**RE: 813-913 WALLGROVE ROAD, HORSLEY PARK - FLOOD IMPACT ASSESSMENT ADDENDUM**

This addendum is prepared in response to the Department of Planning, Industry and Environment's (DPIE) recommendations (DOC21/65477 included as Appendix A) for the proposed 'Gazcorp Industrial Estate' development at 813-913 Wallgrove Road, Horsley Park ('the Site'). A Flood Impact Assessment (FIA) was previously undertaken by BMT for the site (R.M20101.001.01.ModellingReport.pdf included as Appendix B) and was submitted in November 2019 as part of a State Significant Development application (SSD-5248). The proposed development design based on this submission is referred herein as the 'approved design'. In December 2020, Gazcorp submitted an application to modify the approved design and this proposed development design is referred to herein as the 'modified design'. This addendum outlines the assessment of the effect of the modified design on the site flood behaviour and for adjoining properties.

**Subject: Gazcorp Industrial Estate Modification 1 Revised Layout and Earthworks, 813-913 Wallgrove Road, Horsley Park (SSD 5248)**

Title:  
**813-913 Wallsgrove Rd, Horsley Park**  
**100 Year ARI Change in Peak Flood Height**

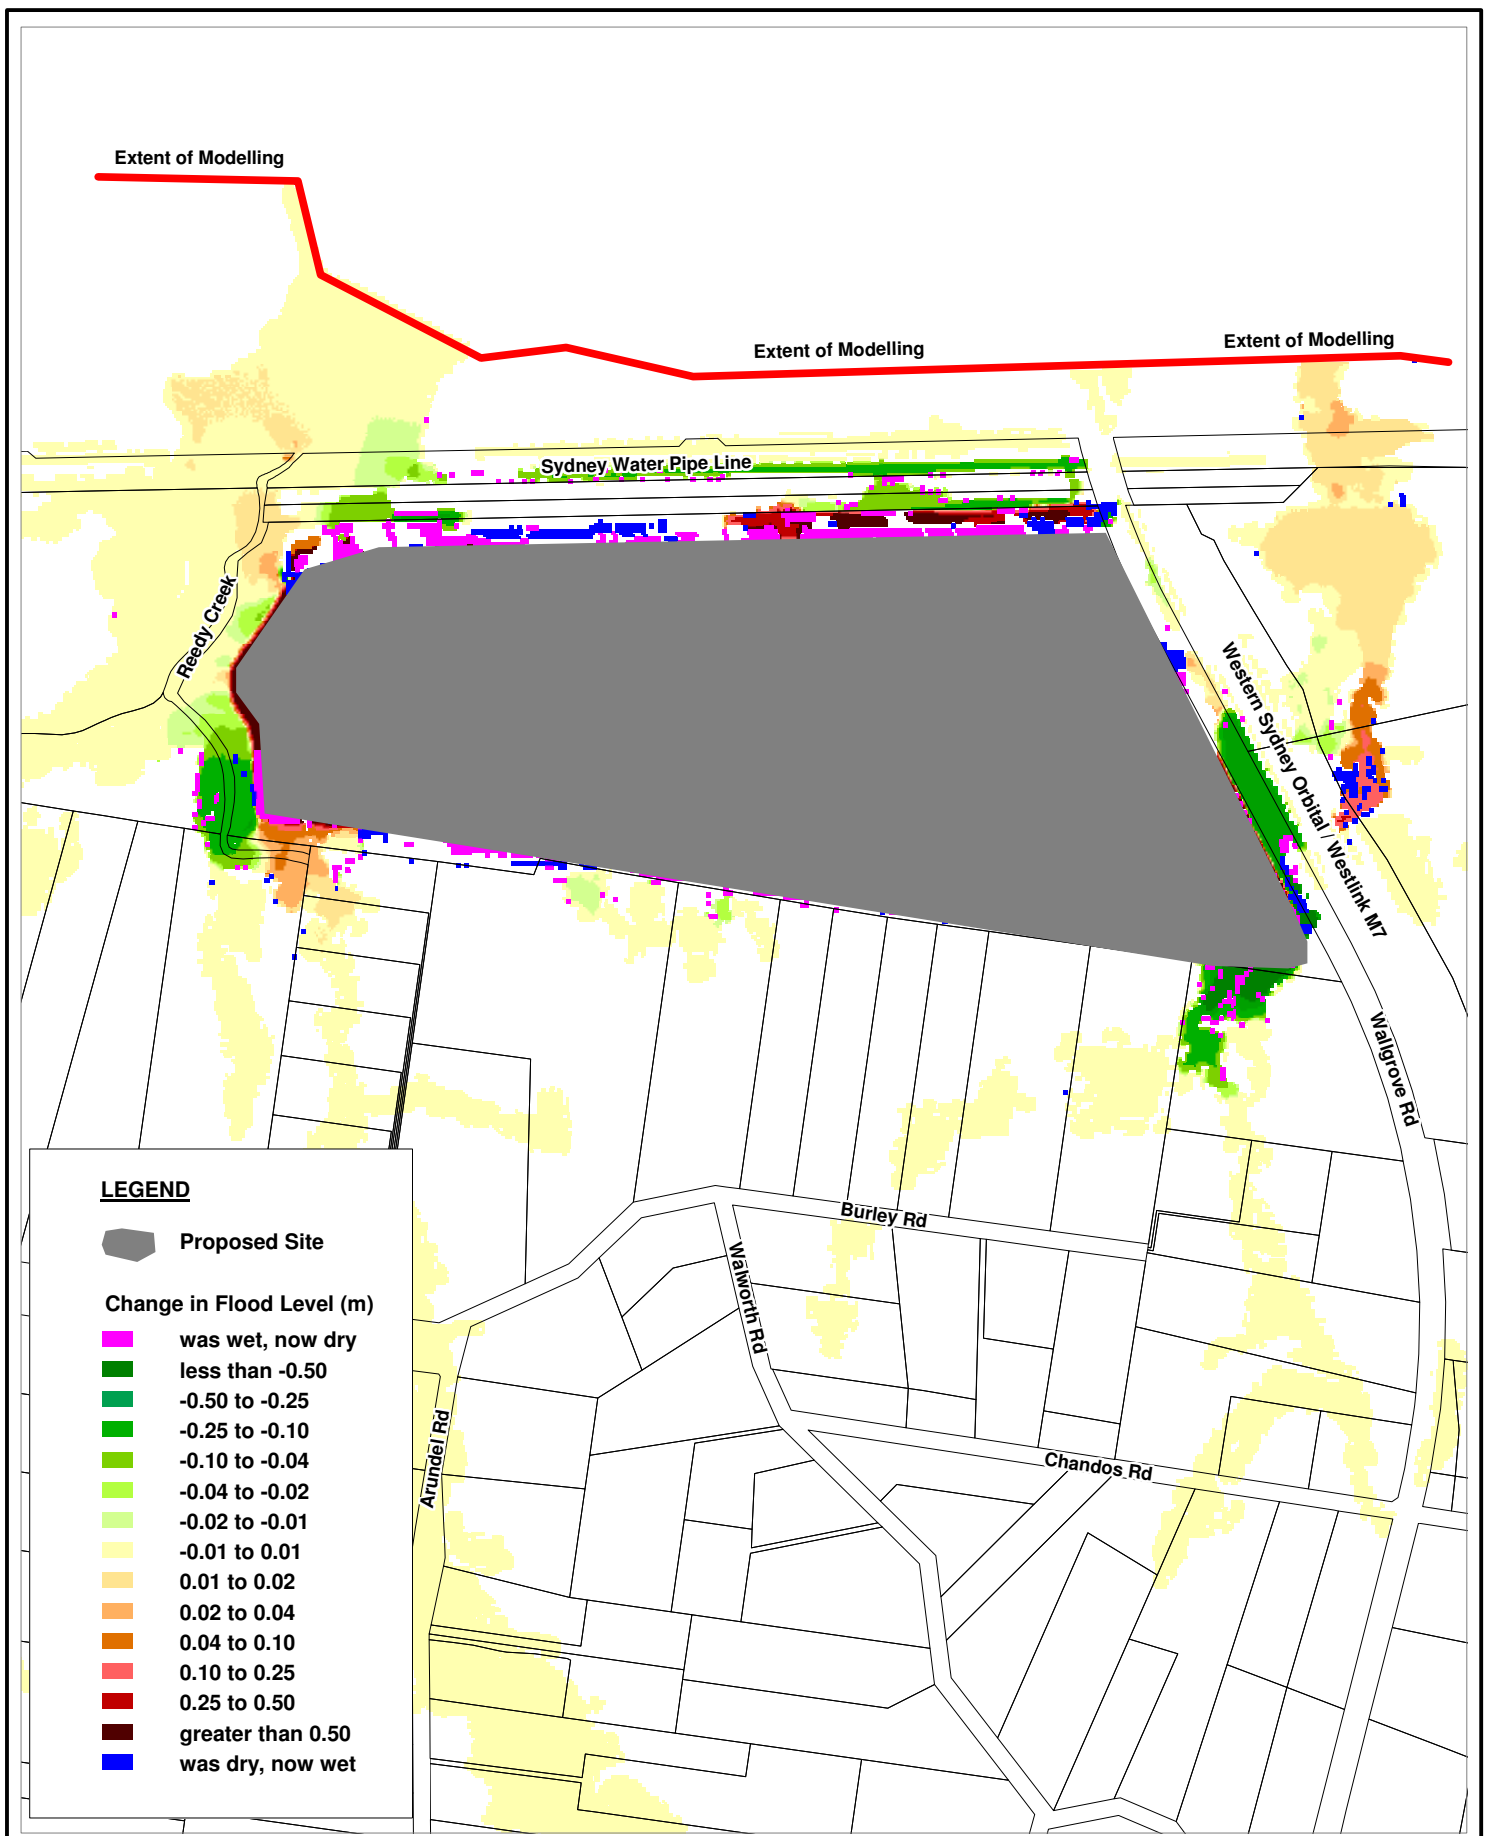
- The Lot 10 footprint indicates that the western and north-western sides of Lot 10 would encroach into the Reedy Creek floodplain; and
- Any filling activities along the western and north-western sides of Lot 10 are likely to impact existing flood storage. Filling activities would cause Reedy Creek to become a hydraulic bottleneck in this location, which would have adverse flooding impacts on Lot 10 and upstream catchment areas.

DPIE recommended the undertaking of "a comprehensive analysis by using the flood models for the Reedy Creek Catchment to evaluate storage loss in the floodplain and flooding impacts at Lot 10 and its adjoining

The development site will accommodate 14 industrial lots in the post-developed conditions. The footprints of the industrial lots within the development site indicate that the western and north-western sides of Lot 10 would approach into the floodplains of the Reddy Creek Catchment.

The filling activities in those locations of Lot 10 are likely to impact the existing floodplain storage. The section of Reddy Creek in these locations (adjacent to Lot 10 and upstream of bulk water pipelines) would become a hydraulic bottleneck, which would have adverse flooding impacts at Lot 10 and the upstream catchment areas. The extent of the impacted area within the floodplains and the quantification of floodplain storage loss can be ascertained by comparing the regrading footprint (Civil Drawings) with the flood map of an 1% AEP Flood Event (Rural Areas Flood Study).

EES recommends that the proponent undertake a comprehensive analysis by using the flood models for the Reddy Creek Catchment to evaluate storage loss in the floodplains and flooding impacts at Lot 10 and its adjoining areas in order to identify the appropriate measures to mitigate adverse flooding impacts in the post-developed conditions of the development site.

As outlined above, the modified design does not propose any changes to the approved design at Lot 10. Accordingly, there would be no change in how the western and north-western sides of Lot 10 encroach into the floodplain of Reedy Creek in the modified design when compared to the approved design. The previous FIA assessed the approved design using the flood models developed for the *Rural Area Flood Study – Ropes, Reedy & Eastern Creeks* (BMT WBM, 2013) to evaluate potential flood impacts. It is therefore considered that:

- The flood conditions outlined in the previous FIA (which was undertaken for the approved design) would be applicable to the modified design at the western and north-western sides of Lot 10 and in Reedy Creek; and thus
- The previous FIA provides a comprehensive analysis of the potential flood impacts of the modified design on Reedy Creek in line with DPIE’s request.

Peak flood level and velocity impacts for the 100 year ARI event for the approved design have been extracted from the previous FIA and shown as attached. The previous FIA and this addendum focus only on flood impacts external to the site, and stormwater management within the development is covered by the Stormwater Concept Plan prepared by Orion Consulting (dated 13<sup>th</sup> November 2020).

Assessments of flood level impacts along the western boundary at Reedy Creek, and of flood velocity impacts at the same location are provided in Section 6.2 and 6.3 of the previous FIA respectively and address the flood-related comments supplied in DPIE’s response.
